December 3, 2018

Ref: Parcel 4213001016-www.epcdevplanreview.com

I am writing in regards to the application for Variance for the Newcombs Extended Family, 12220 Preston Place, Peyton, CO. 80831.

VARIANCE SPECIAL
USE
ZONE R3
DATE: 1-3-93
OWN BY BILL MOORE
B/M CONST.

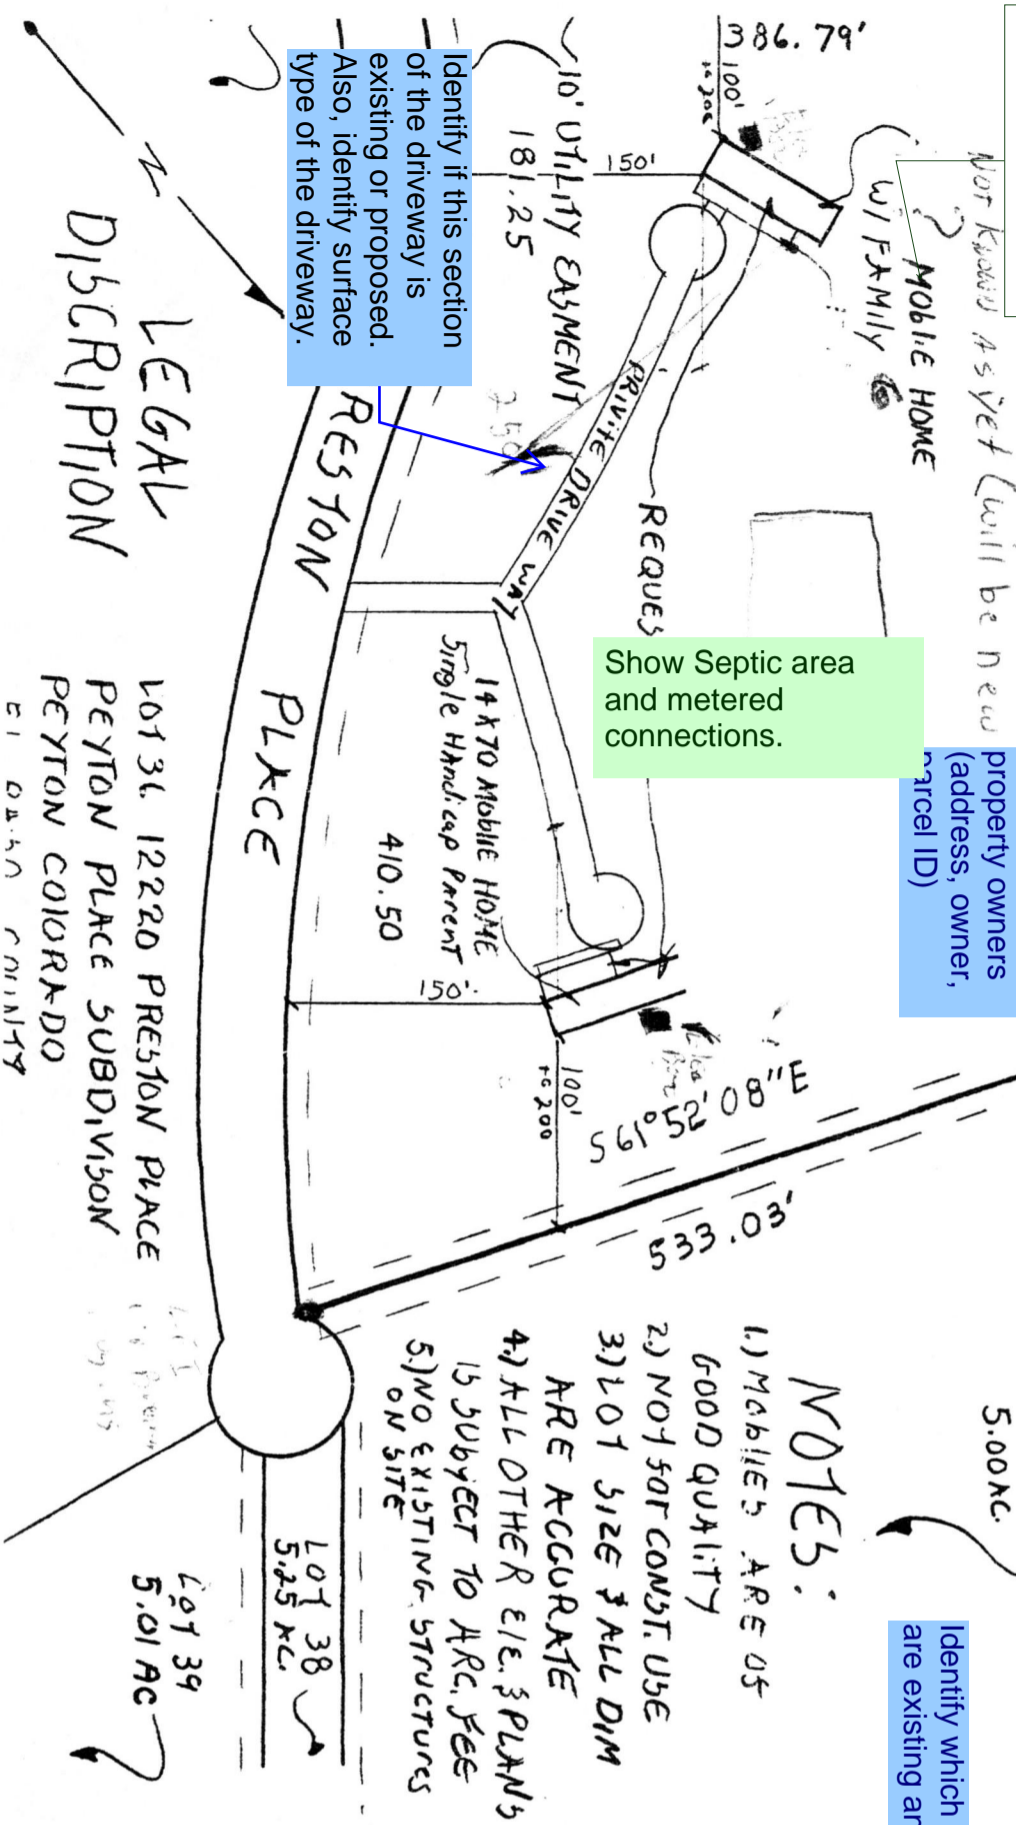
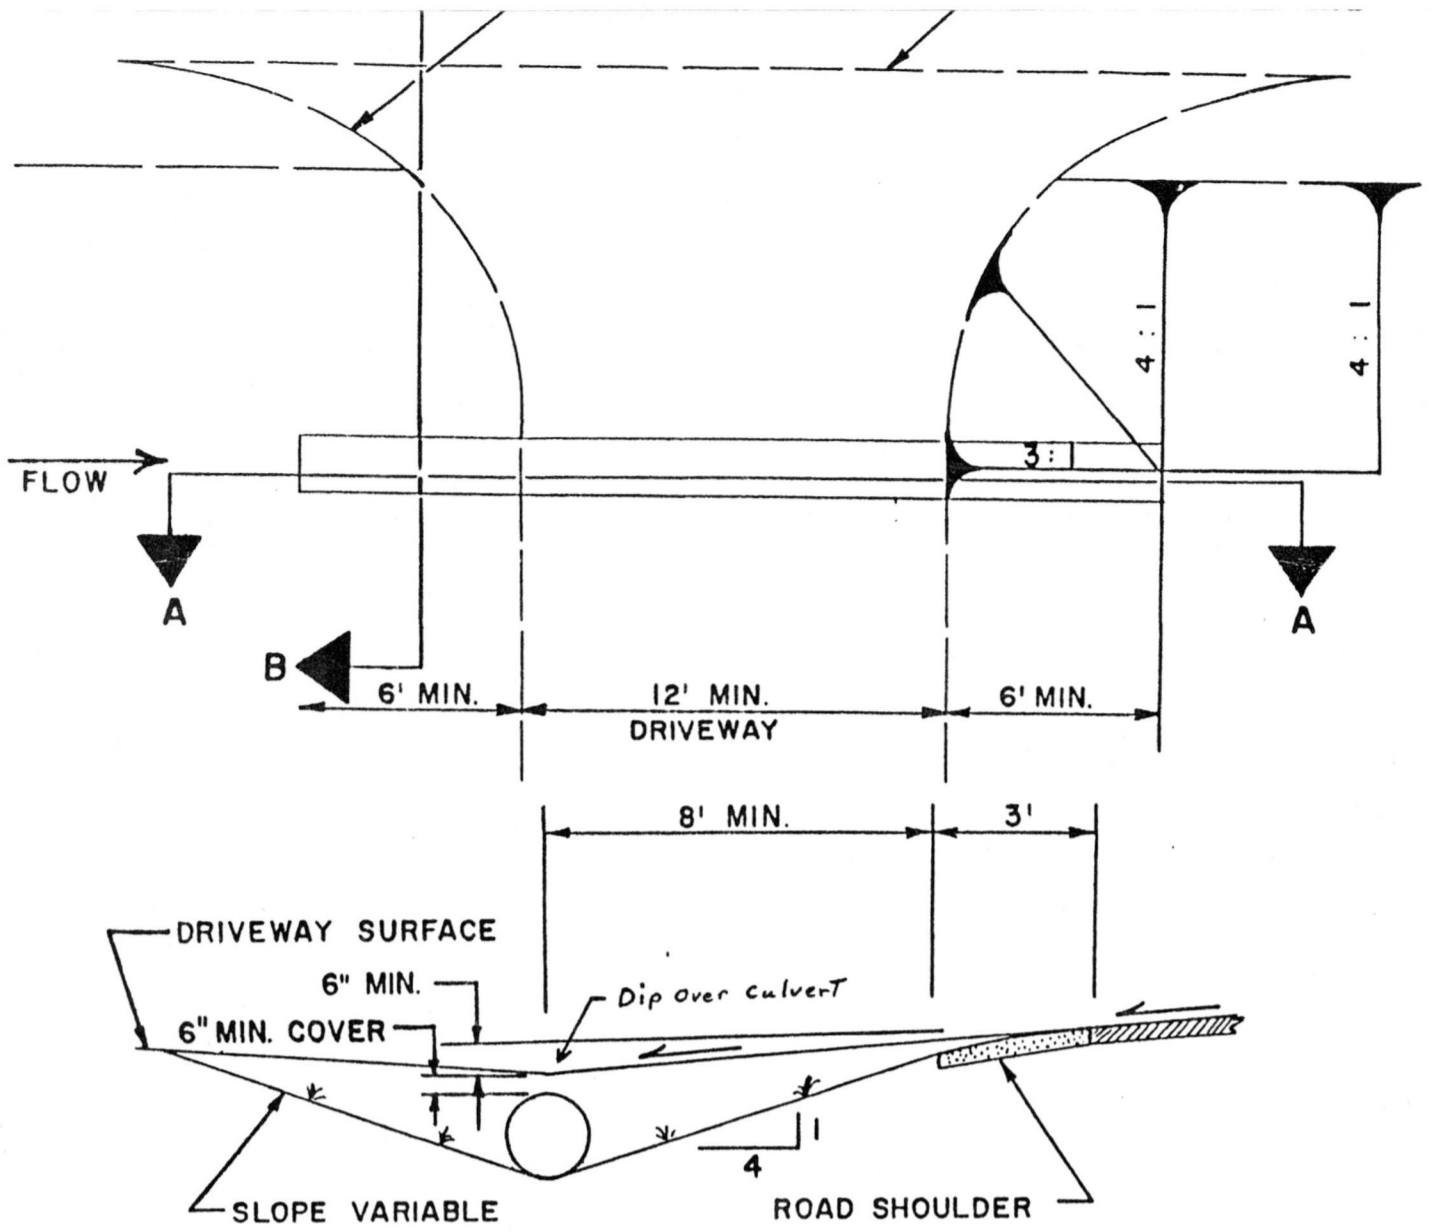
2. Specs of use: This spec plan is dated 1993 and is clearly incorrect. The current 14x70 Mobil Home is not placed where indicated on this plan. See photos by Covenant requested drive-by. The home is straight from driveway, does not show the garage placement, is missing the torn up well shed the eye sore since 1993, is not indicated on this plan, nor any livestock out buildings. Including but not limited to; a modification needs to be presented to Zoning that part of the back lot will have a expansion of Hwy 24 that will effect the size of the lot. 5.01 acres will not the the correct size of this lot, a 4 acre with current existing buildings would be correct. I request Zoning to obtain the Plans of the Hwy Improvements, from CDOT in Mrs. Newcombs possession, that will be effecting this lot size, before any further request be made for this Variance. Lot size and drawing is incorrect. These plans from 1993 were just copied and submitted. This is indicating no Licensed General Contractor or Authored Agent dated 2018, with the assumption you would not catch that date. So this project will be family built as before, with the same history from 1993, with no General Contractor direction or guidance. I am aware Mrs. Newcomb can be her own Contractor, but nothing ever gets finished or looks professional.

3. Per the Plans and Specs, this new Mobile Home, (??? not described) will be placed over a open hole, that currently has natural debris "compost" and some construction debris "concrete", placed into the hole as filler. A request was made to Mindy, El Paso County Compliance, to do a drive-by visual inspection, on the current conditions of 12220 Preston Pl., Peyton Colorado. This was requested, so El Paso County Compliance would assist as a neutral arbitration, on behalf of the current land owners, adjacent to this variance request, due to fear of retaliation, that has already been threatened to all owners.
